From: Martyn White
Sent: 22 October 2021 14:06
To: Maria Tomalova
Subject: RE: Kents Farmhouse at Climping CM/49/21/DOC

Re Kents House, Climping CM/49/21/DOC

Drawing Title
**WINDOW AND DOOR
DETAILS**

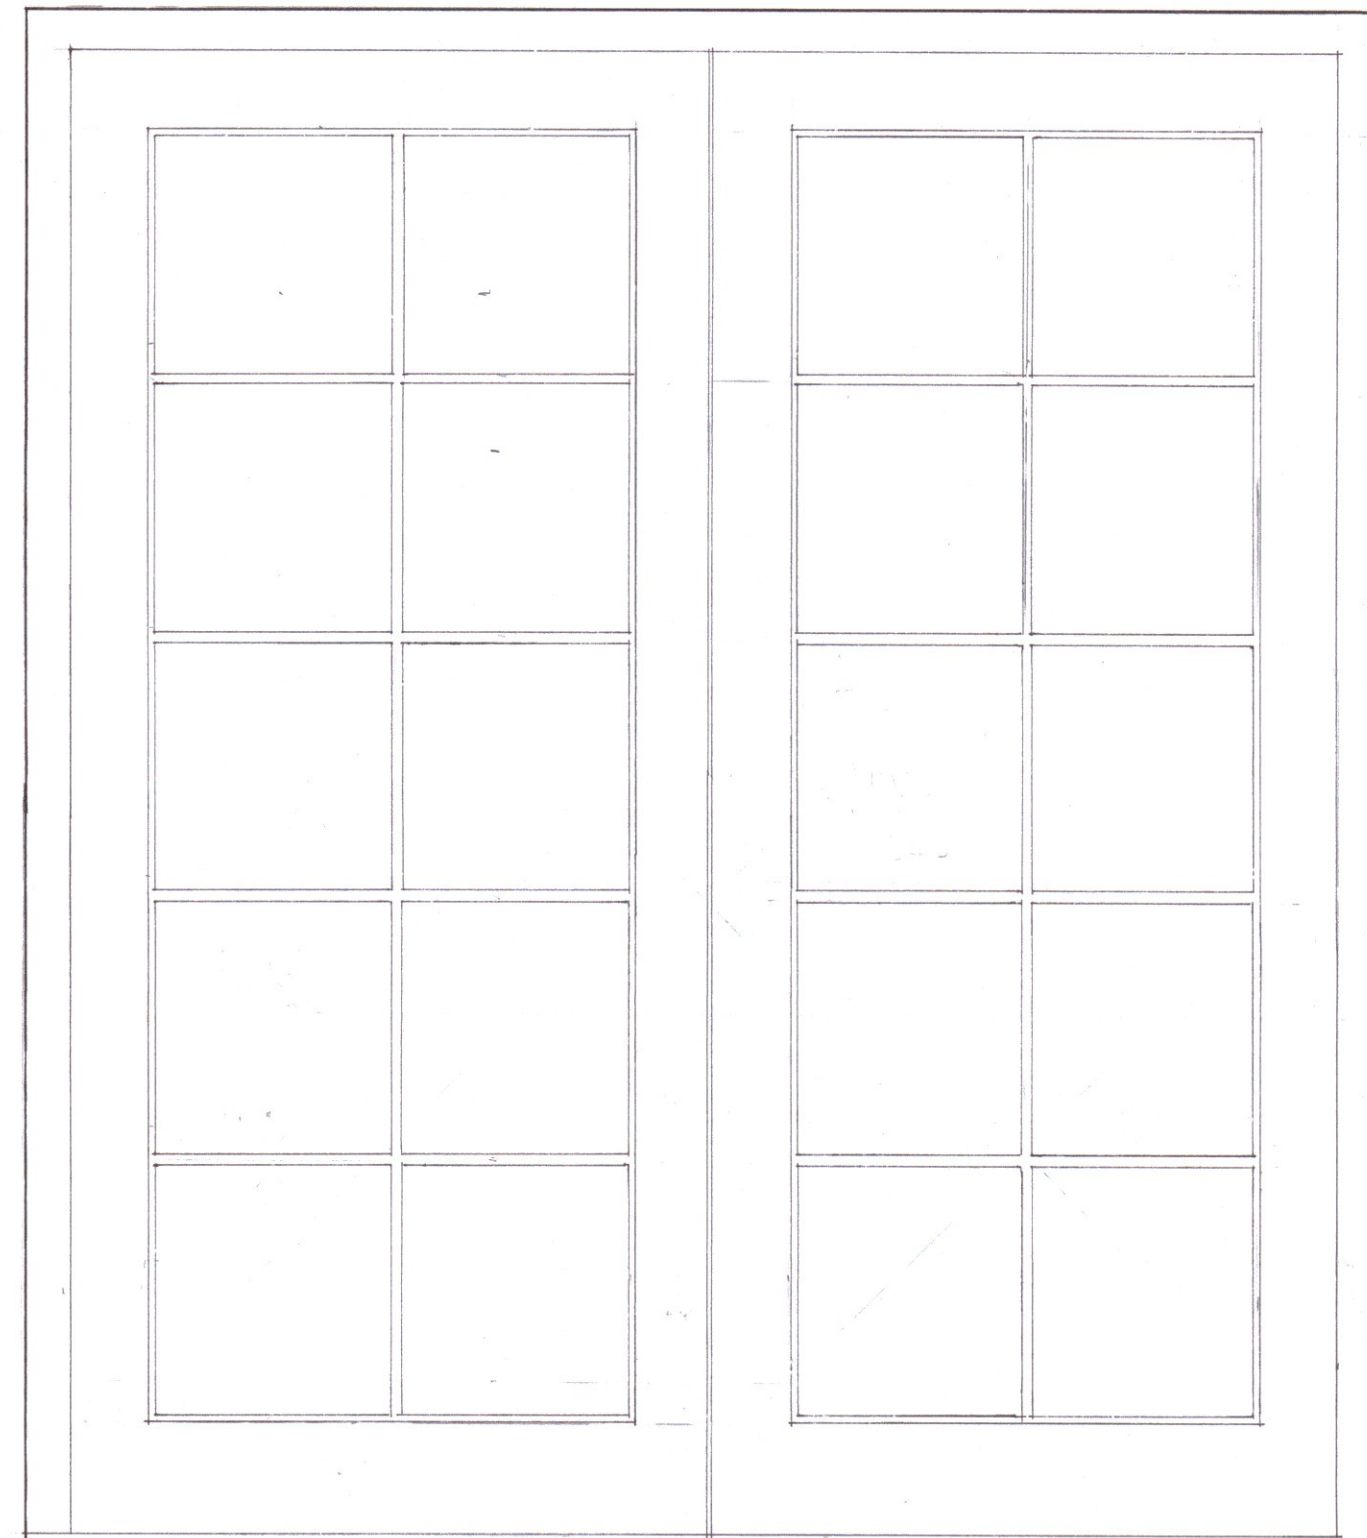
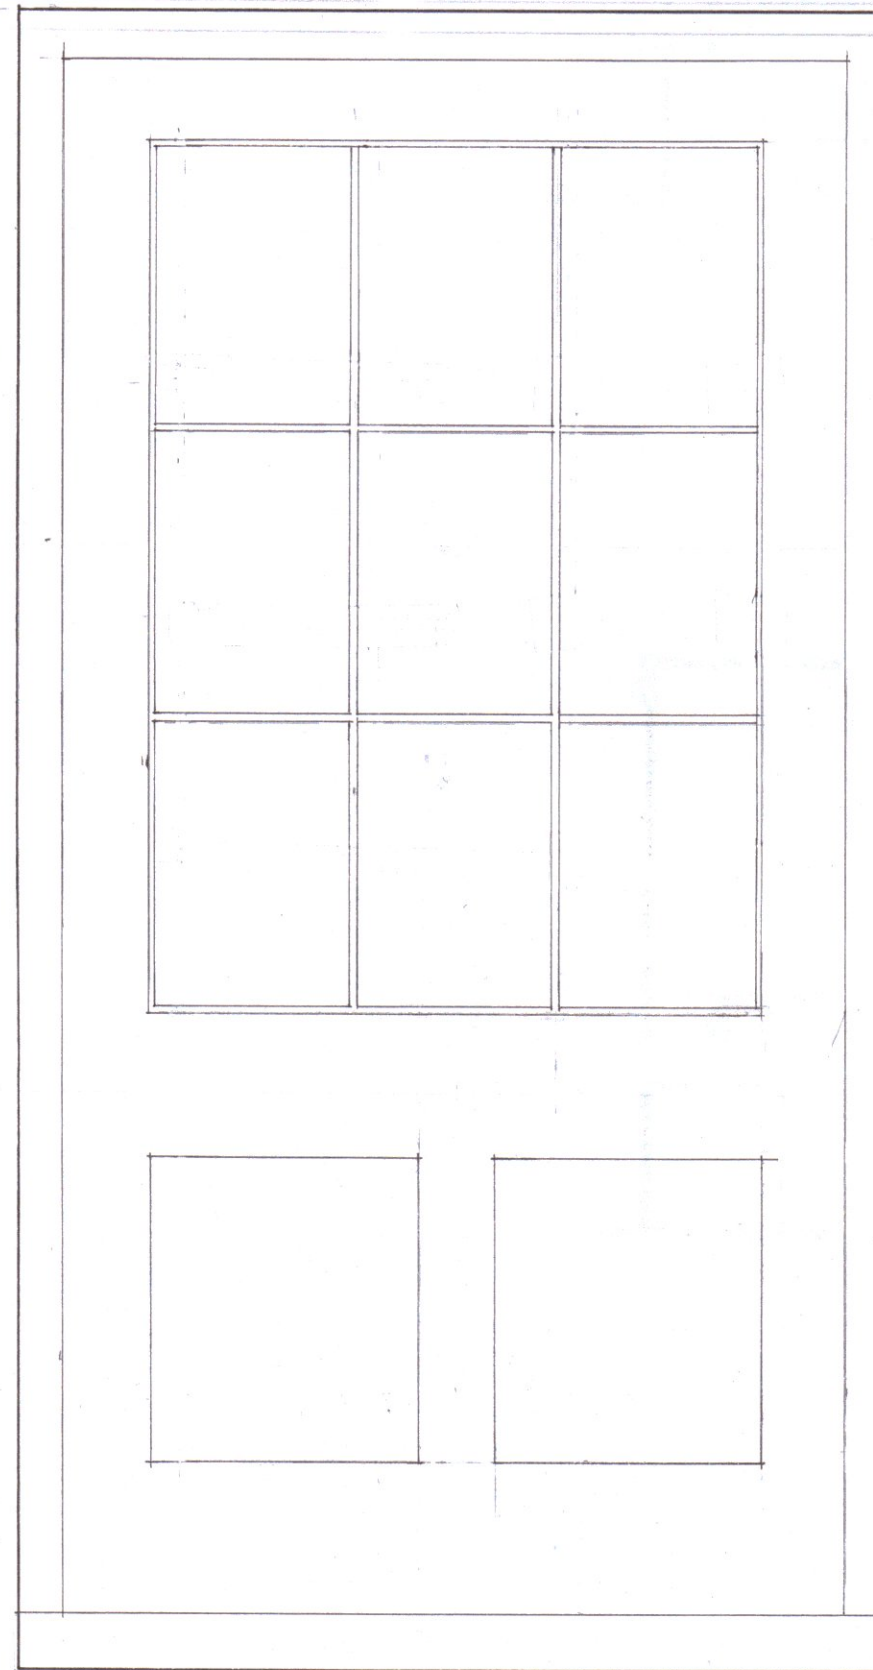
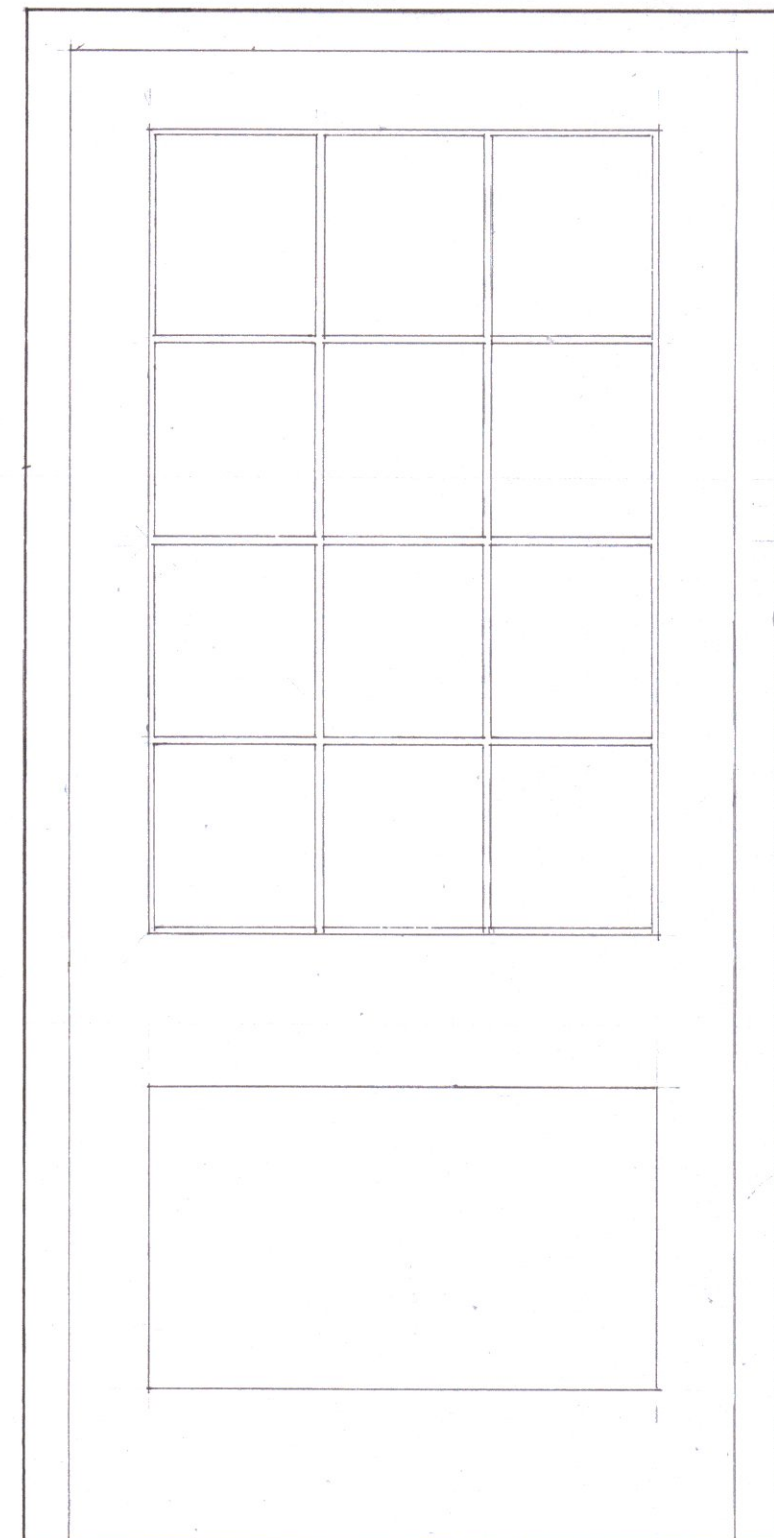
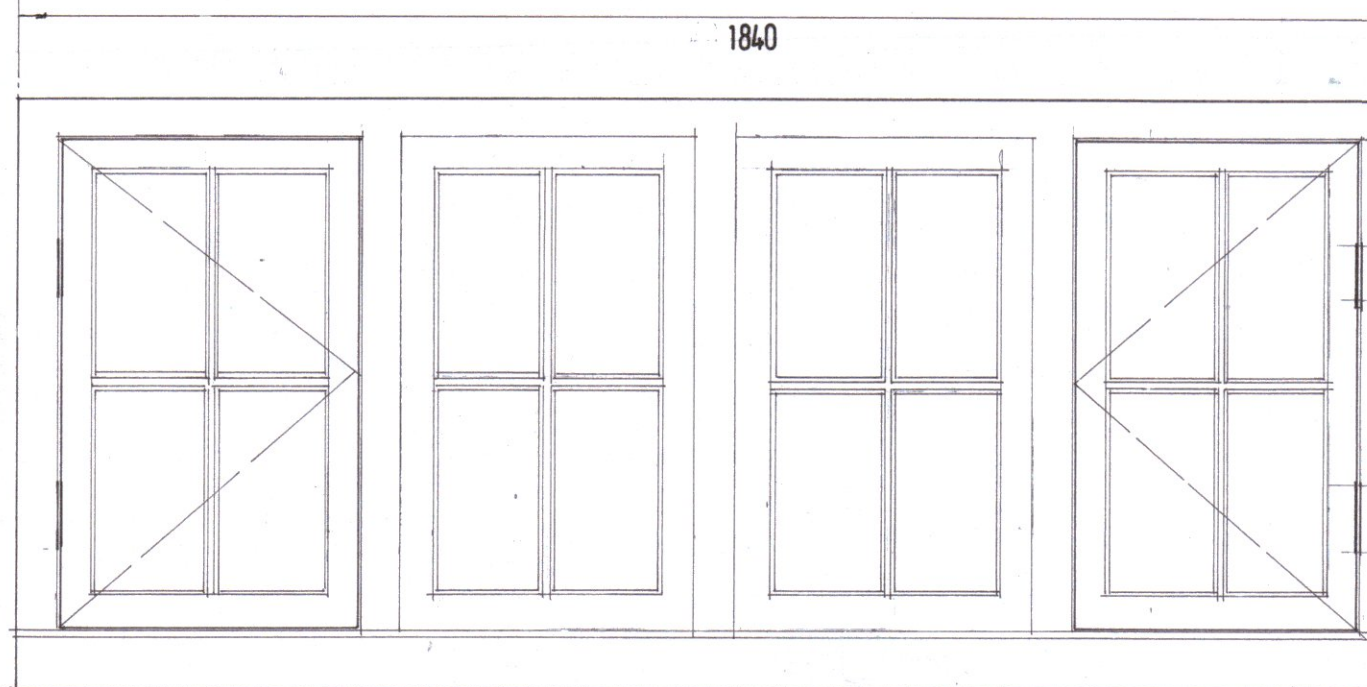
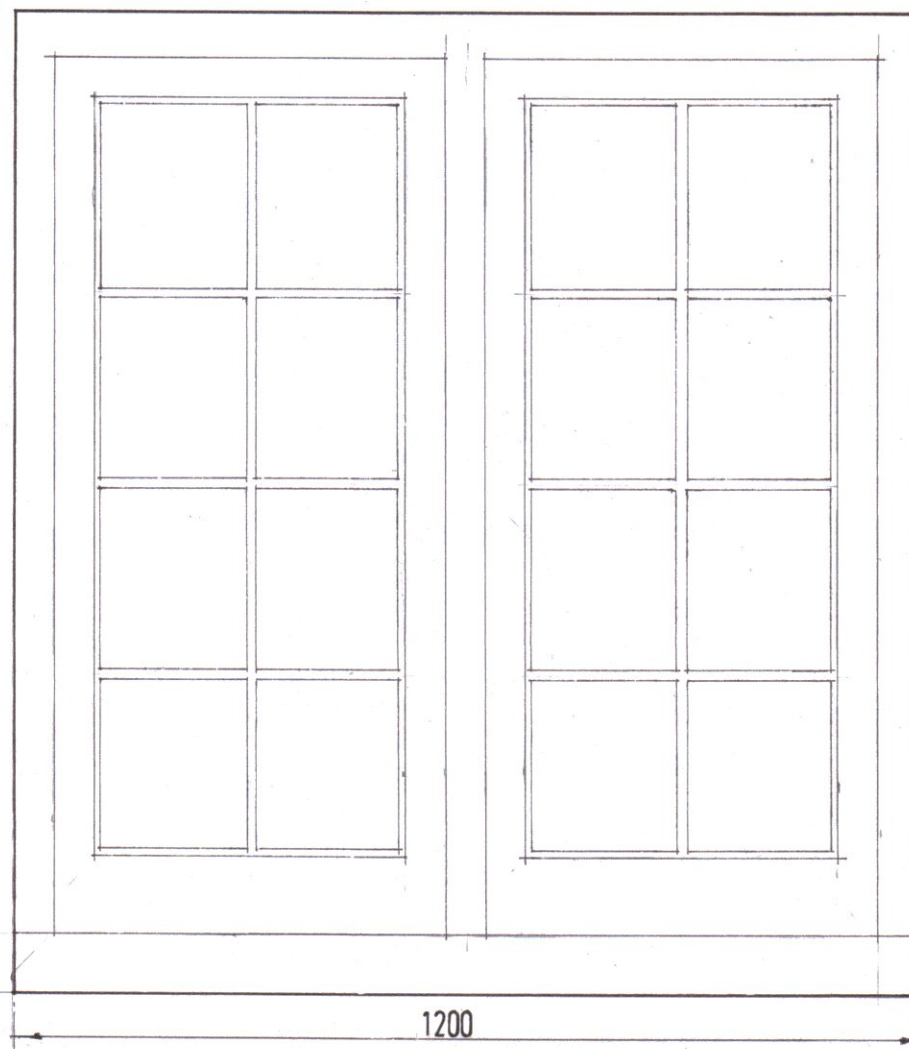
Condition no 2 - The drawing for the window sections has come from the joinery company, but they have been instructed following the Discharge of this Condition that all window glazing must be the 4 x 4 x 4 design and not 24mm

The window bars are to be a match to the glazing bars elsewhere in the house they ~~are to~~ frame up each pane of glass i.e. not applied or stuck on imitation glazing bars

In summary the windows, doors and their various sections are to match the period of the house
